## **Able Marine Energy Park**

### *Material Change 2*

### **Amendment Order**

**The Able Marine Energy Park (Amendment) Order 202[ ]**

SCHEDULE 1
HARBOUR LIMITS

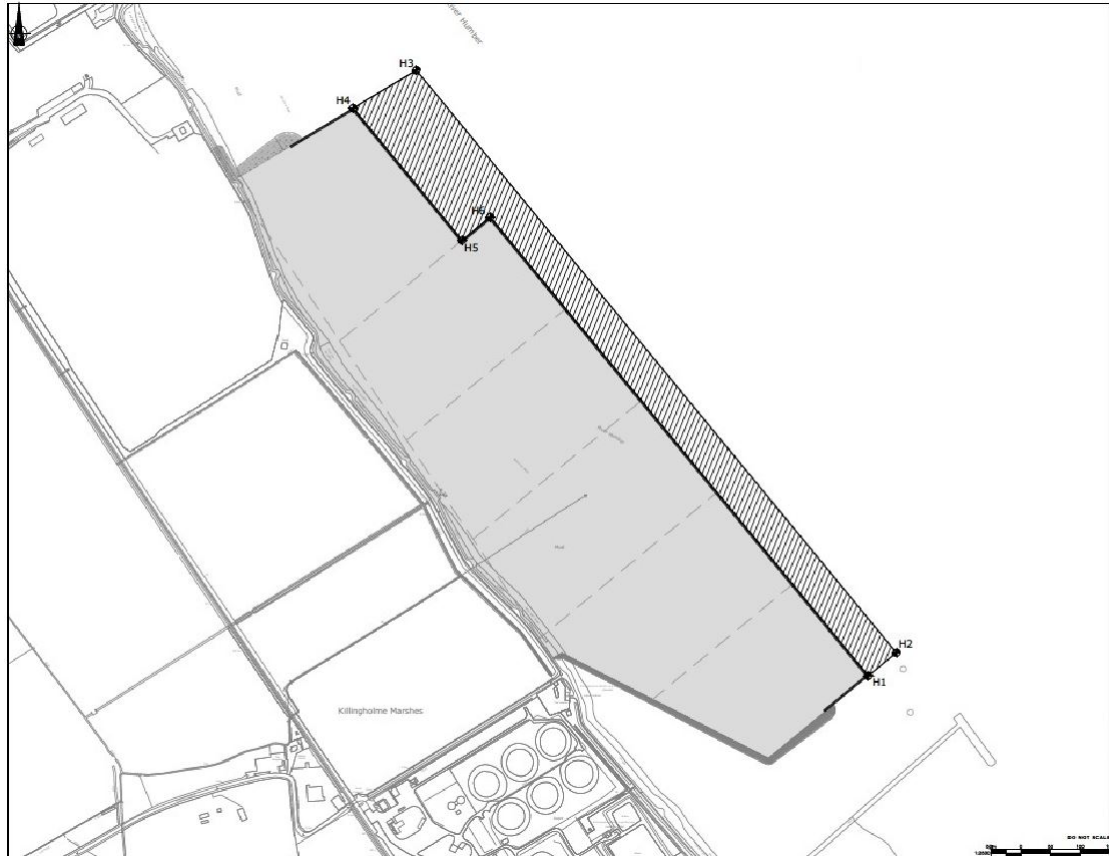
(a) for the table in paragraph 1 substitute the following table—

<b>Table</b>		
<i>Latitude</i>	<i>Longitude</i>	<i>Label</i>
53°38.965'N	00°12.701'W	H1
53°38.985'N	00°12.657'W	H2
53°39.525'N	00°13.367'W	H3
53°39.492'N	00°13.465'W	H4
53°39.370'N	00°13.304'W	H5
53°39.390'N	00°13.260'W	H6

(b) after the table, for the plan showing the harbour limits substitute the plan in Schedule 1 of this Order.
